Ribble Valley Borough Council  
Housing & Development Control

Application no: **3/2024/0115**

Address: **Land Adjacent to Ferns Northcote Road Langho BB6 8BG**

Proposal: **Proposed residential development of eight detached dwelling houses (pursuant to variation of conditions 2 (approved plans) and 14 (visibility splay) on permission 3/2022/0537. To allow for a reduced visibility splay at the access.)**

client: oak tree developments
project: northcote road, langhol
project number: J327909
scale: 1:250@A3
drawing title:
visibility splays based on 85th percentile speeds
drawing number:
J32-7909-PS-001

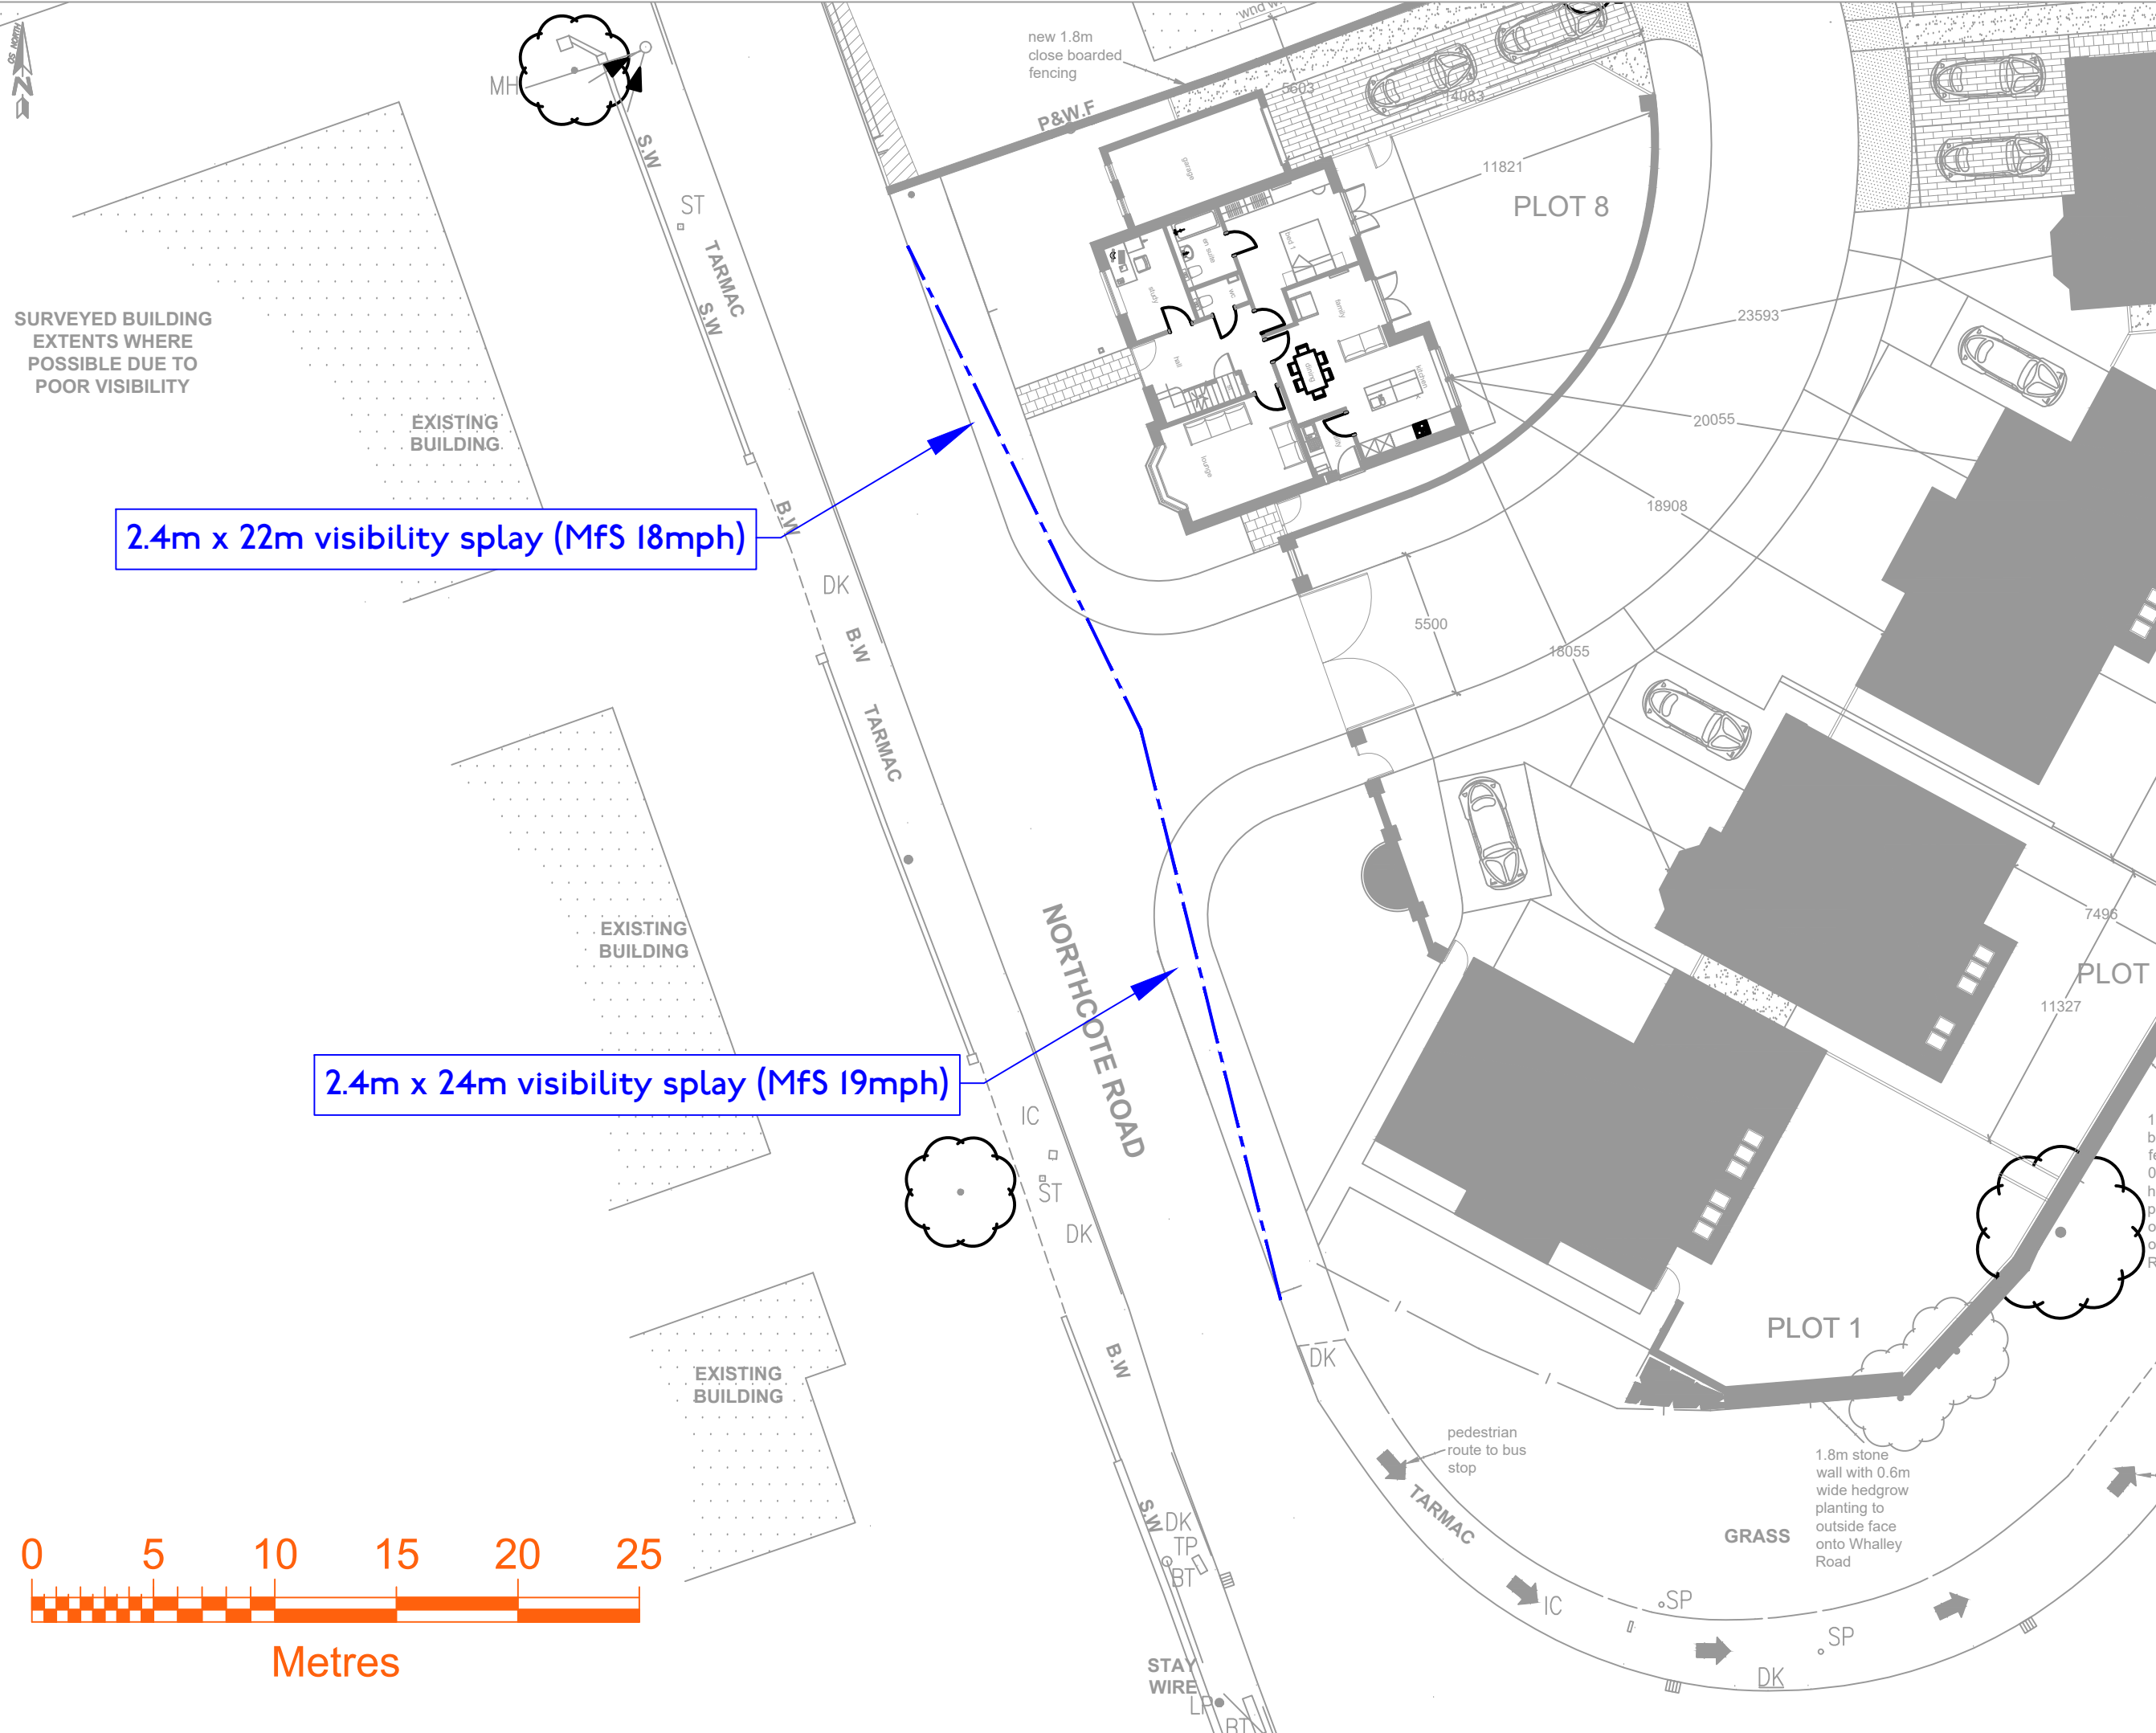
For the site access to comply with the national visibility guidance, following the traffic survey, the LHA would expect the access to be able to achieve visibility splays of 2.4m x 24m to the north and 22m to the south.

The Agent, as shown on Mode drawing number J32-7909-PS-001 titled "Visibility Splays based on 85<sup>th</sup> percentile speeds," shows that the access can achieve the required splays above. Therefore, the LHA have no objection to the variation of condition.

For the site access to comply with the national visibility guidance, following the traffic survey, the LHA would expect the access to be able to achieve visibility splays of 2.4m x 24m to the north and 22m to the south.

The Agent, as shown on Mode drawing number J32-7909-PS-001 titled "Visibility Splays based on 85<sup>th</sup> percentile speeds," shows that the access can achieve the required splays above. Therefore, the LHA have no objection to the variation of condition.
